PERMIT NUMBER
SFD2403-0050

Description: 38 x 46 Cabin A				
Type: SINGLE FAMILY DWELLING	Subtype: SFD CRAWL	Status: ISSUED	Applied: 3/11/2024 DJ	
Parcel No: 9587-58-5620.000	Site Address: 641 BARBECUE CHURCH RD SANFORD,NC 27332		Approved: 9/24/2025 KBG	
Subdivision: DS-01582-001-001M F WICKER ESTATE	Block:	Lot:	Issued: 10/15/2024 MM	
Lot Sq Ft: 0	Building Sq Ft: 0	Zoning:	Finaled:	
Valuation: \$0.00	Occupancy Type:	Construction Type:	Expired:	
No. Buildings: 0	No. Stories: 0	No. Unites: 0		
Details:

FIRST FLOOR PLAN
SCALE: 1/4" = 1'-0"

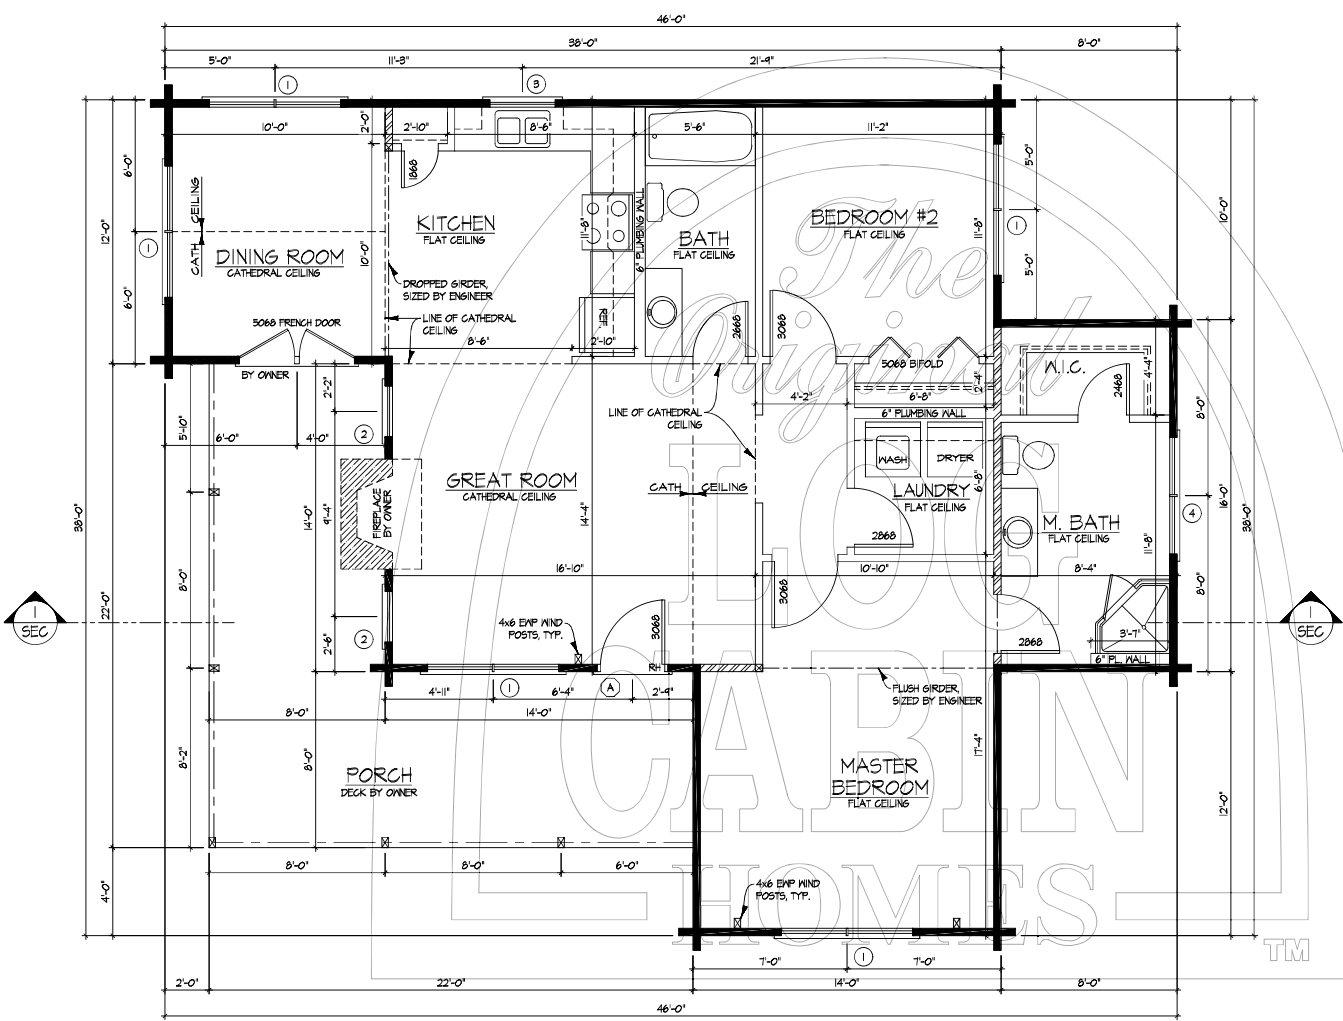
REVIEW TYPE	REVIEWER	SENT DATE	DUE DATE	RETURNED DATE	STATUS	REMARKS	NOTES
SFD INTAKE	CP Bucket	3/11/2024		9/24/2025	APPROVED		
ENVIRONMENTAL	MARK OSBORNE	3/11/2024	3/25/2024	4/5/2024	APPROVED		will need backhoe pits
RESIDENTIAL BUILDING	Brad Sutton	8/5/2024	8/8/2024	8/9/2024	DISAPPROVED		Need a floor plan to scale with dimensions of all doors and windows as well as all rooms labelled
RESIDENTIAL BUILDING	Brad Sutton	8/14/2024	8/19/2024	8/19/2024	APPROVED
